Please ask for: Mrs D Johnson
Email: daun.johnson@arun.gov.uk
Telephone: 01903 737762
Our Ref: BR/170/20/PL
Your Ref:
Date: 29th July 2020

Application for Planning Permission

Development: Cladding of approved replacement external stair.
Location: 86 Annandale Avenue Bognor Regis PO21 2EX

PROPOSED SITE PLAN
1:100

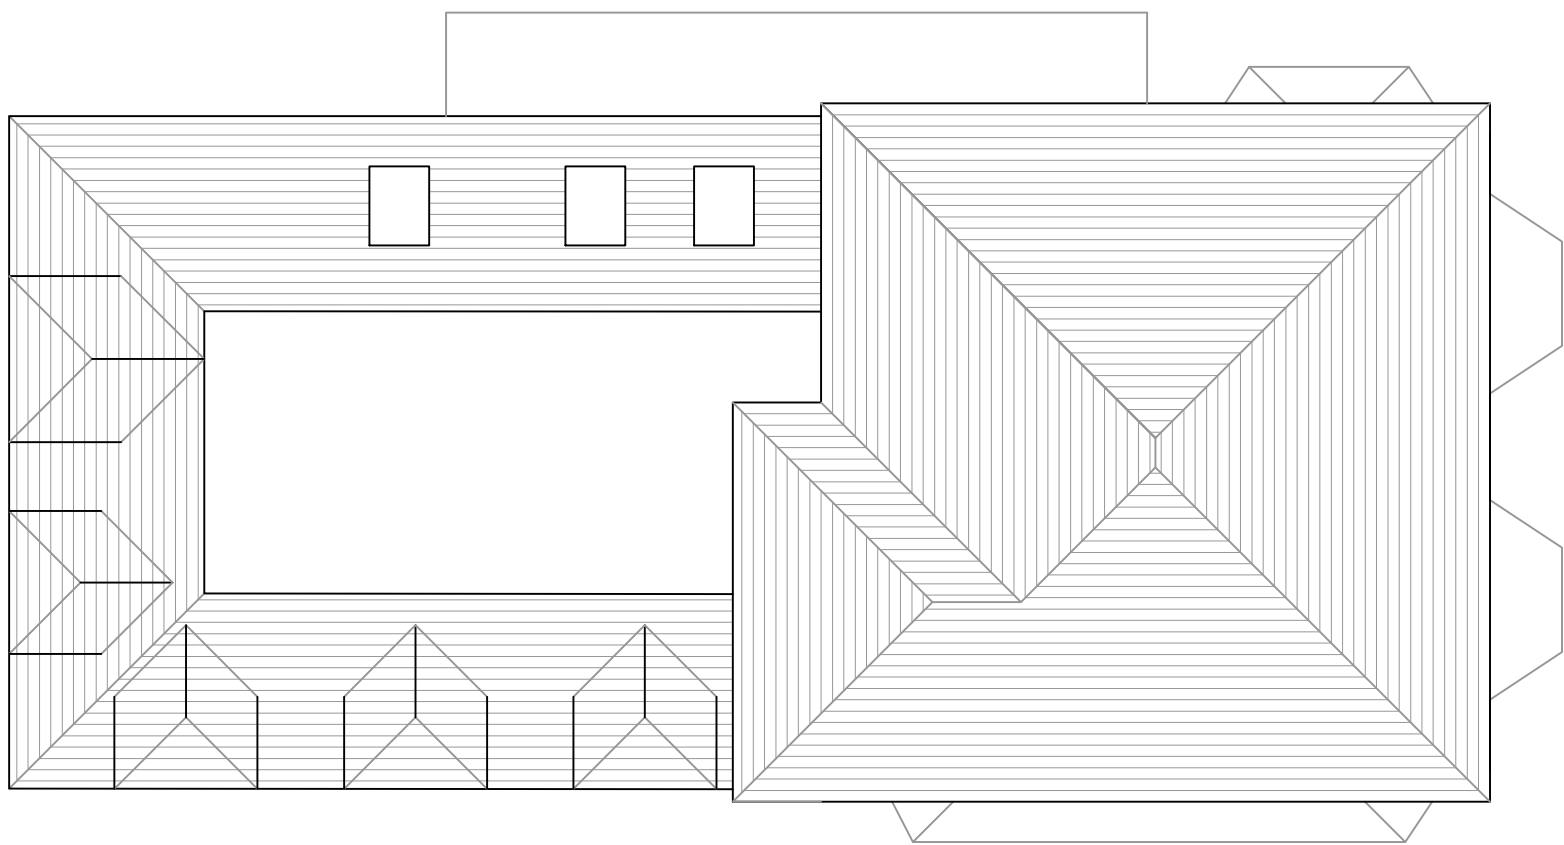
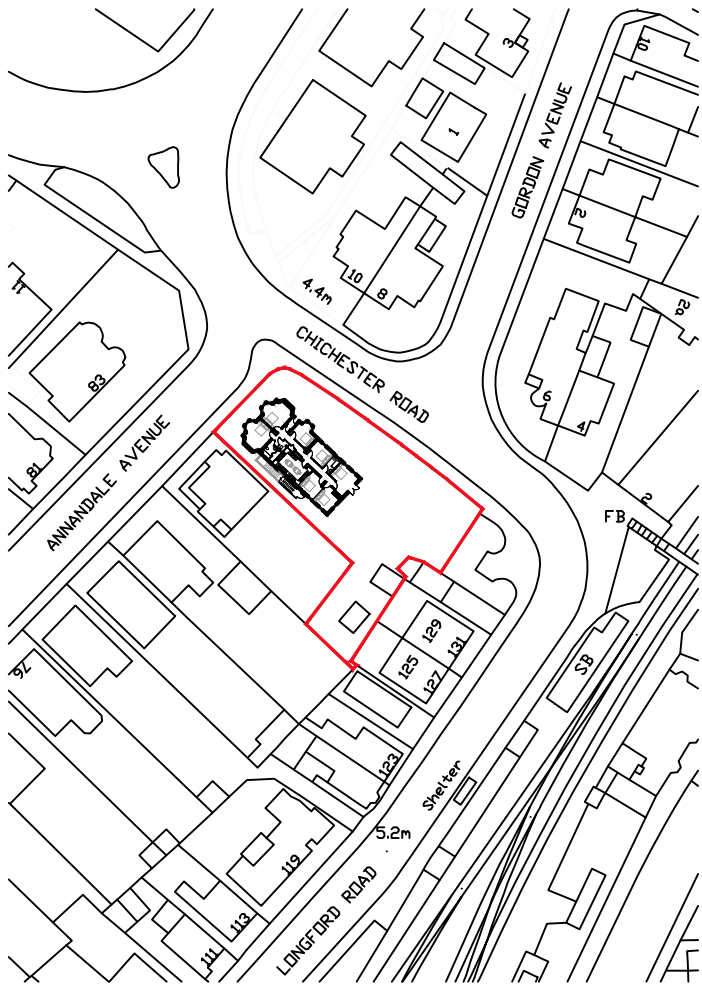
On the block plan, please highlight the proposed works.
